District : Cherwell
Application no : 17/00271/DISC
Proposal : Discharge of conditions 15 (access details) and 24 (SUDS) maintenance and Management Plan) of 16/01000/F
Location : Buildings 455 and 457, Heyford Park.

Transport

Condition 24 SUDS Maintenance and Management Plan

BUS STOP KERBING DETAIL

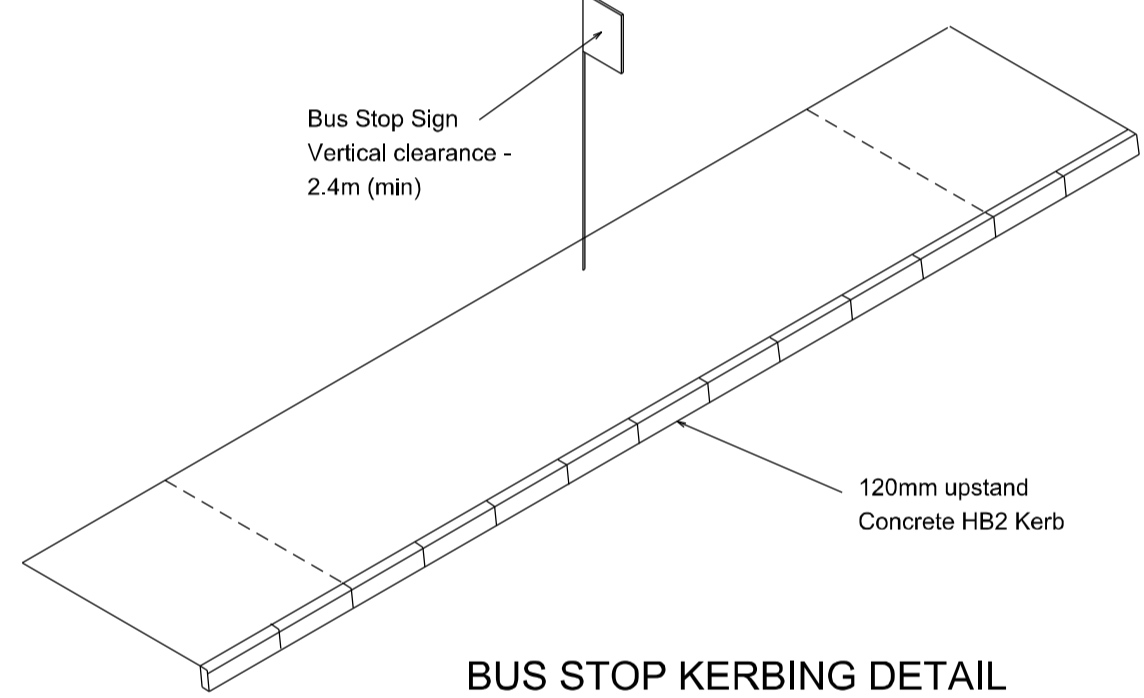
- Adoptable trees within the footway and verge will command a commuted sum and will need to be installed in approved tree pits.
- Bus stops adjacent to the uncontrolled crossing are not ideal in terms of visibility for both pedestrians and drivers approaching the crossing. The western one needs to move more westerly because it currently blocks the junction opposite as well as obstructing visibility for the crossing.

TACTILE CROSSING DETAIL HSD-1100-102

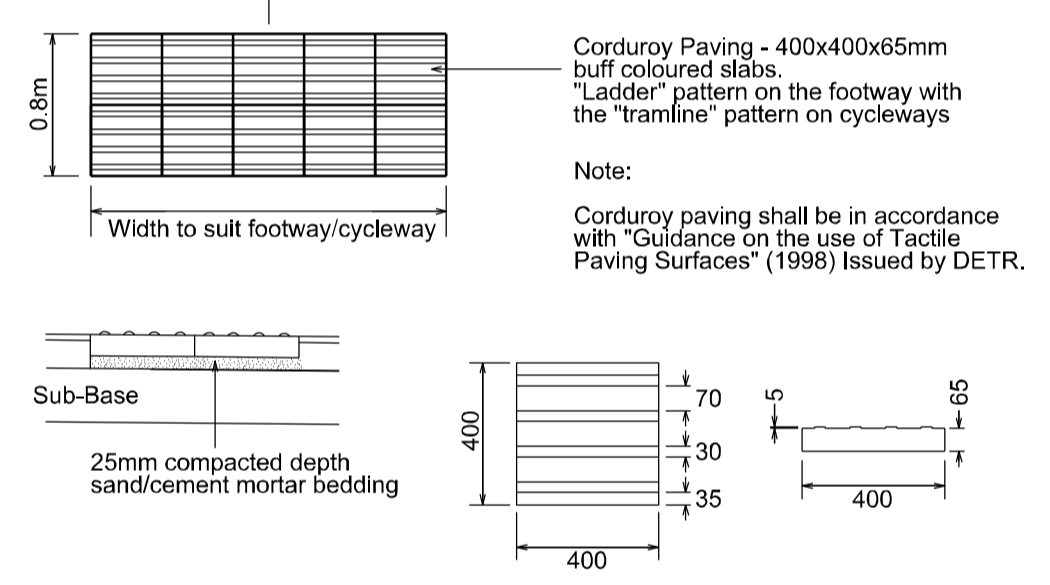
- The plans appear to show the tactile crossing as a 25mm upstand, although the key is not that clear. This will need changing prior to technical audit and construction but is not a reason for objection.

S278 VILLAGE CENTRE

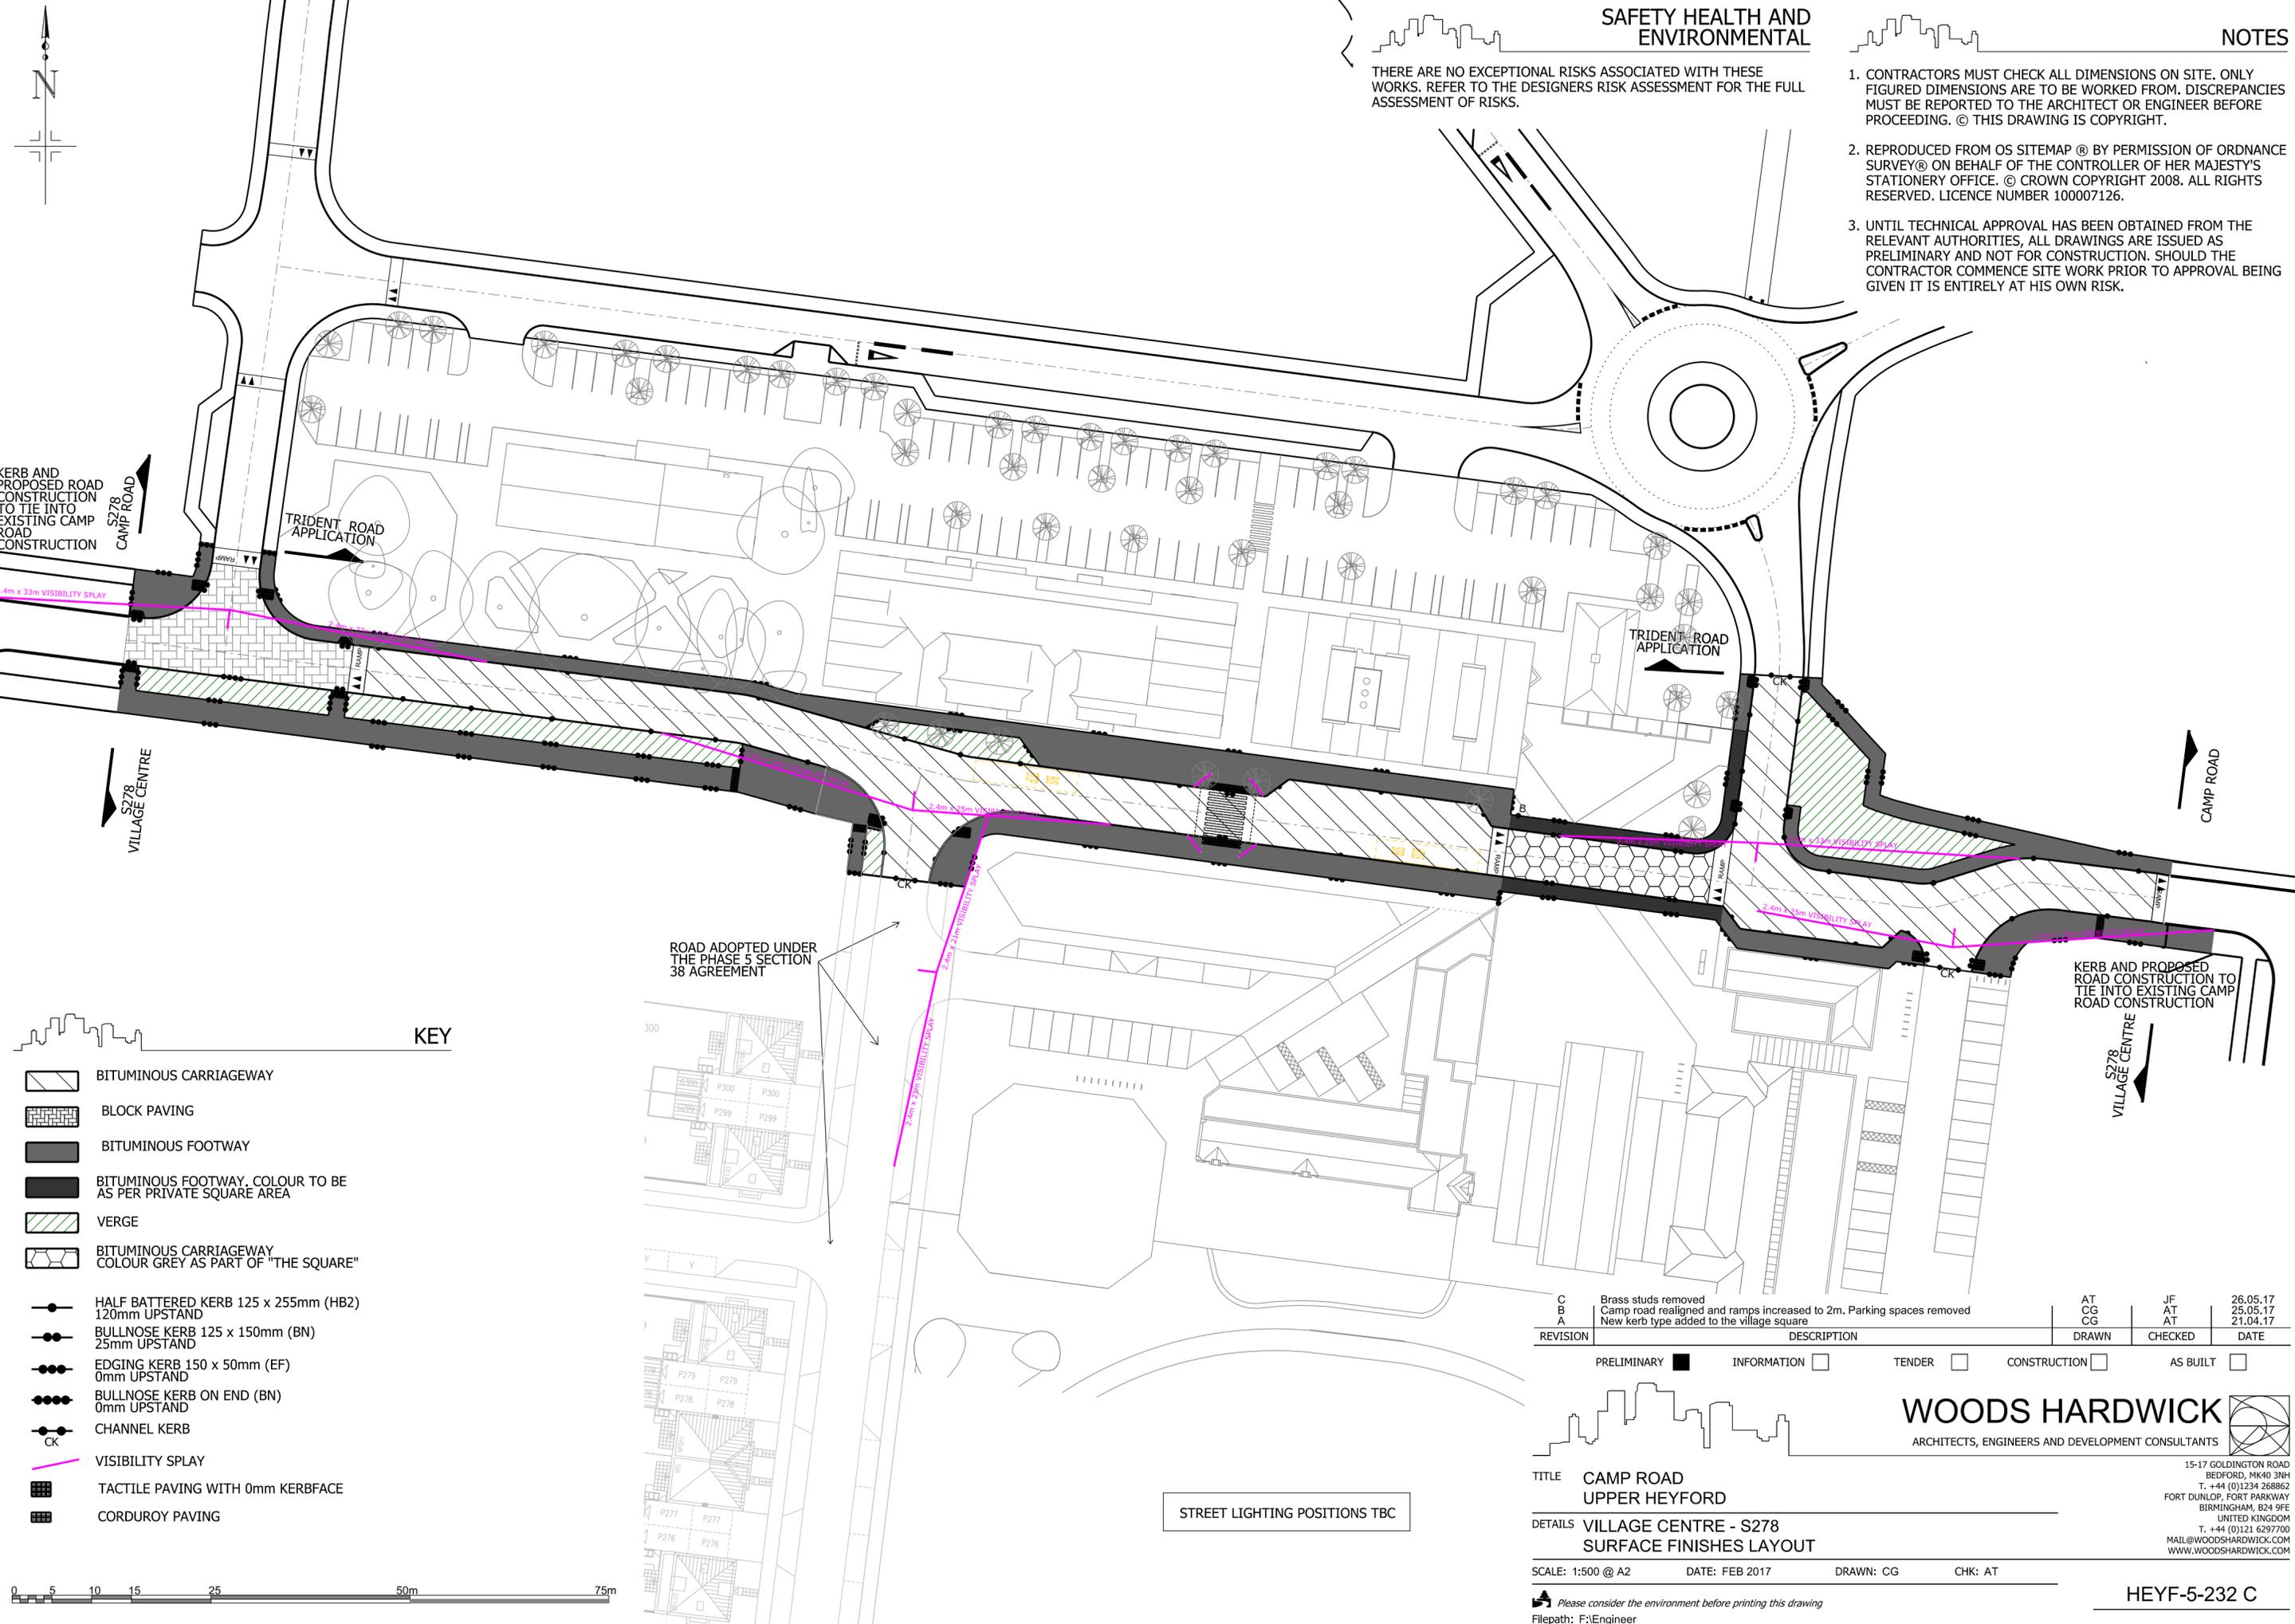
- The County would prefer not to adopt it with thin verge strips between road and footway for maintenance reasons. However this does make the footway safer and is not a reason for objection.

- The layout appears to be designed for a 20mph design speed in which case the visibility splays are acceptable as shown.
- Road and footway widths will need to comply with the Heyford Park design Code.
